**KIRKLEES METROPOLITAN COUNCIL
INVESTMENT & REGENERATION SERVICE**

Reference No: 2021/62/90610/W

Site Address: 35, Bent Lea, Bradley, Huddersfield, HD2 1QW

Description: Erection of single storey extension to rear, addition of first floor accommodation within raised roof space and alterations

Project no: HD2-2050
Stage: PLN
Rev: C
Sht: 003

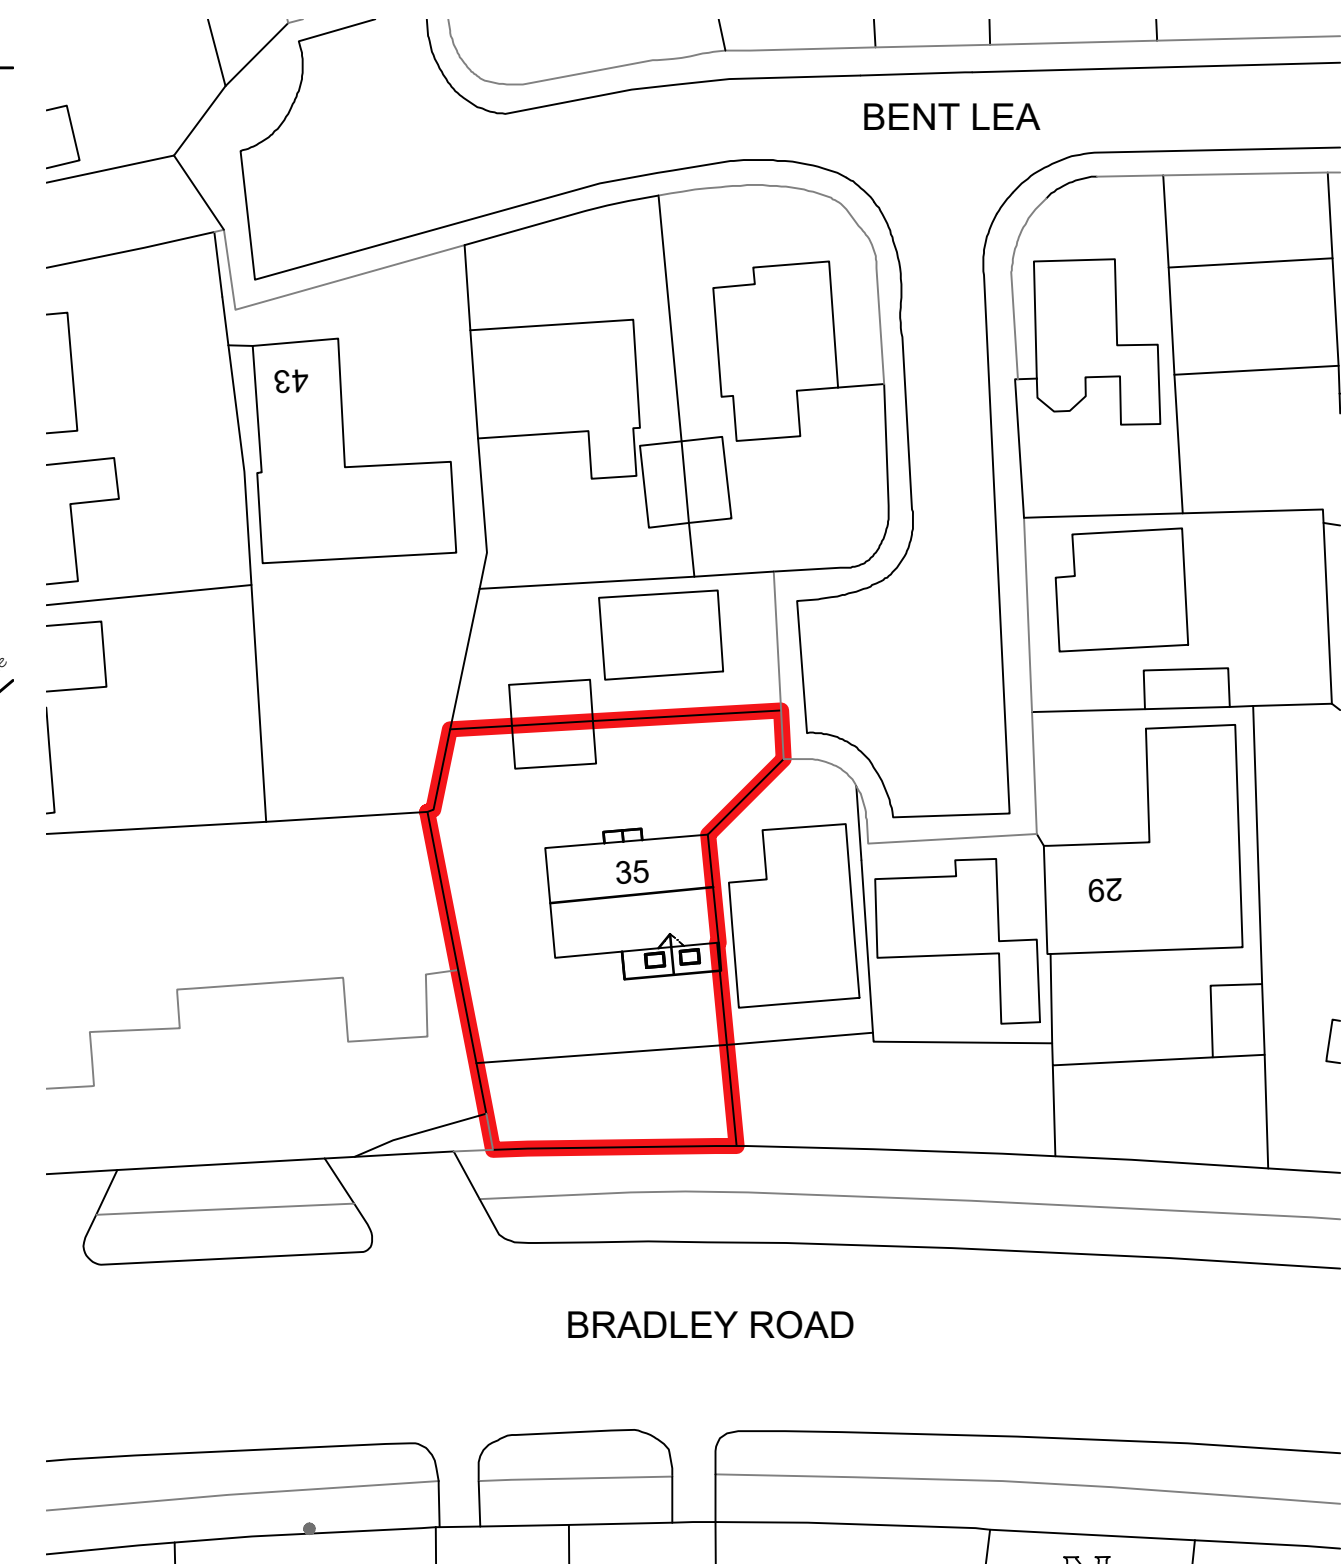
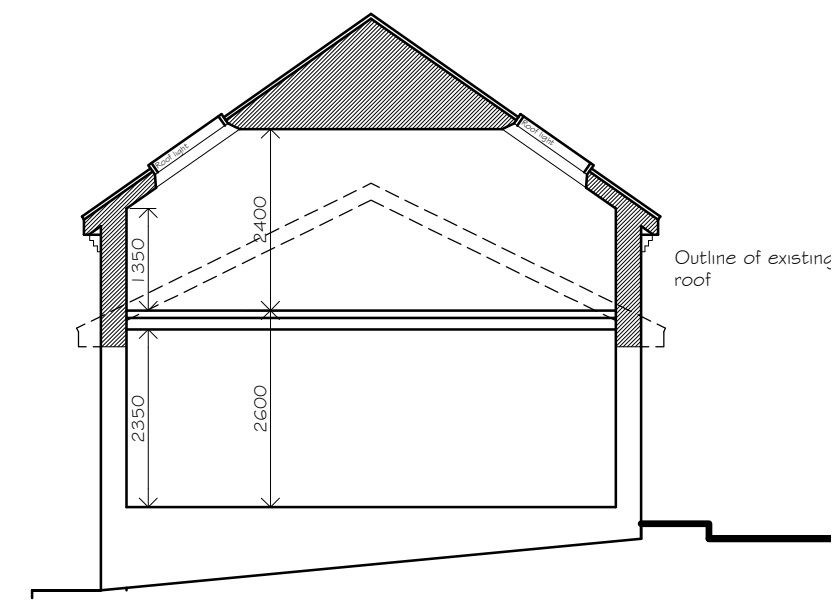
In addition the increase in ridge height, would take the dwelling higher than the side extension of the neighbour at no.35, as evidenced on the street scene drawing. This further highlights that the proposal would lead to the dwelling becoming prominent in the street scene, further adding to concerns with the design of the scheme.

Project no: D2-2050	Stage PLN	Rev C	Sht 002
-------------------------------	---------------------	-----------------	-------------------

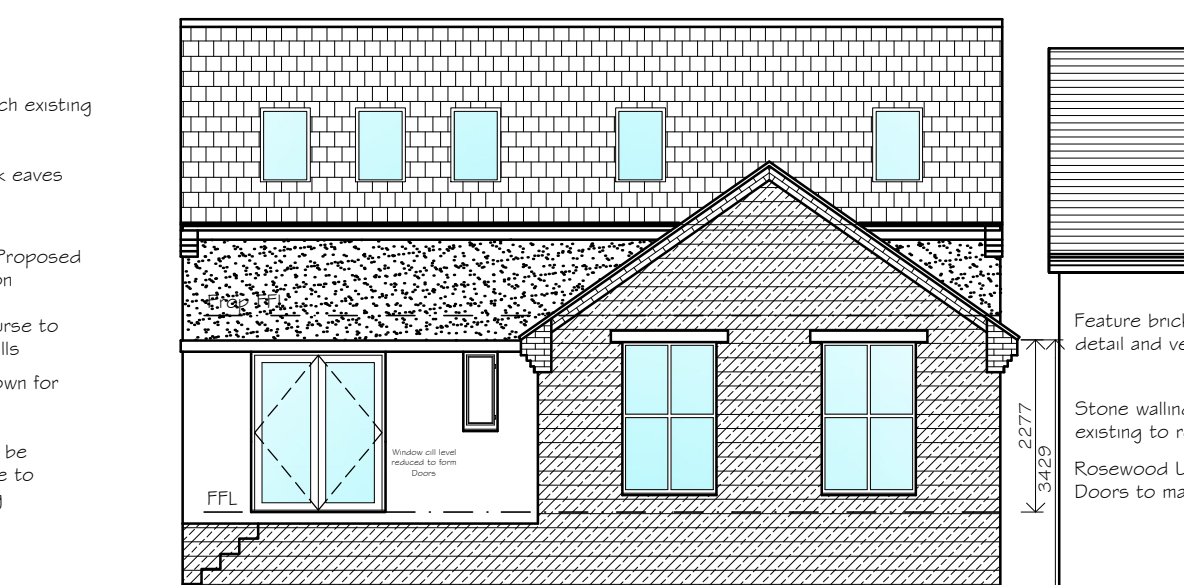
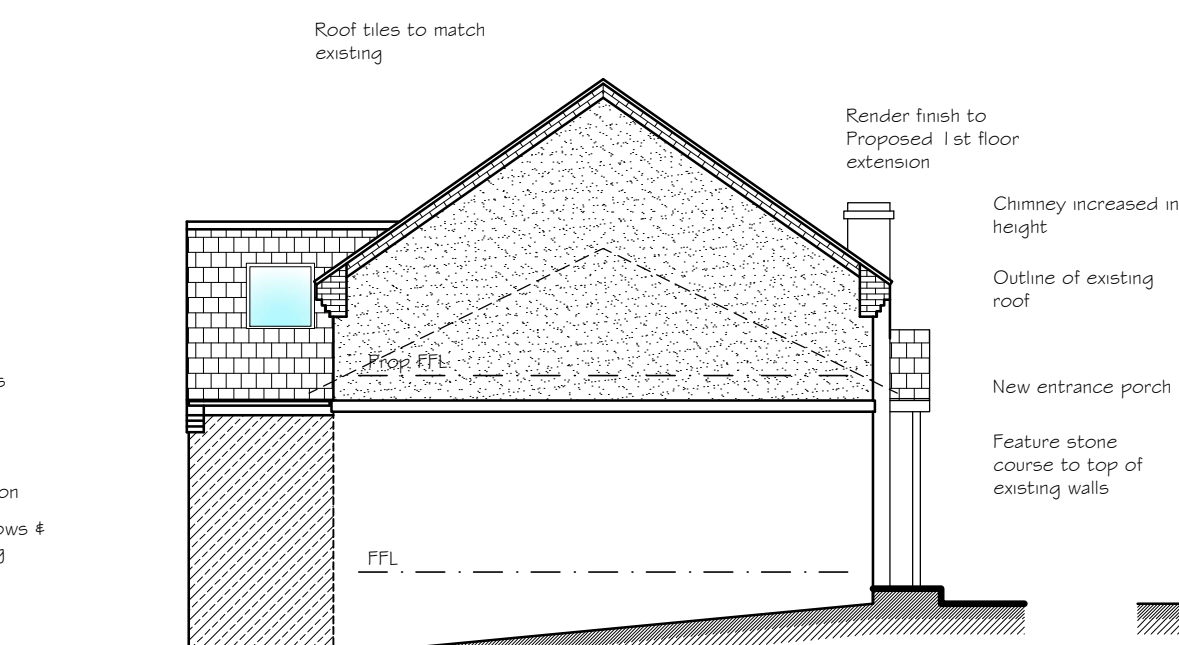
However, the scheme proposed includes the provision of a 1.5 metre band of render around the whole property, leading to the property having a significantly high eave's height at 4 metres. When this design is considered along with other dwellings in the immediate area, which all have low eave's heights, with little or no gap between the head of the window and the eave's of the roof, it is considered that this design approach would be out of keeping with this well established character and the extension would not be subservient to the original property. It is noted that render is evident in the local areas as a secondary material and this is not objected to in principle.
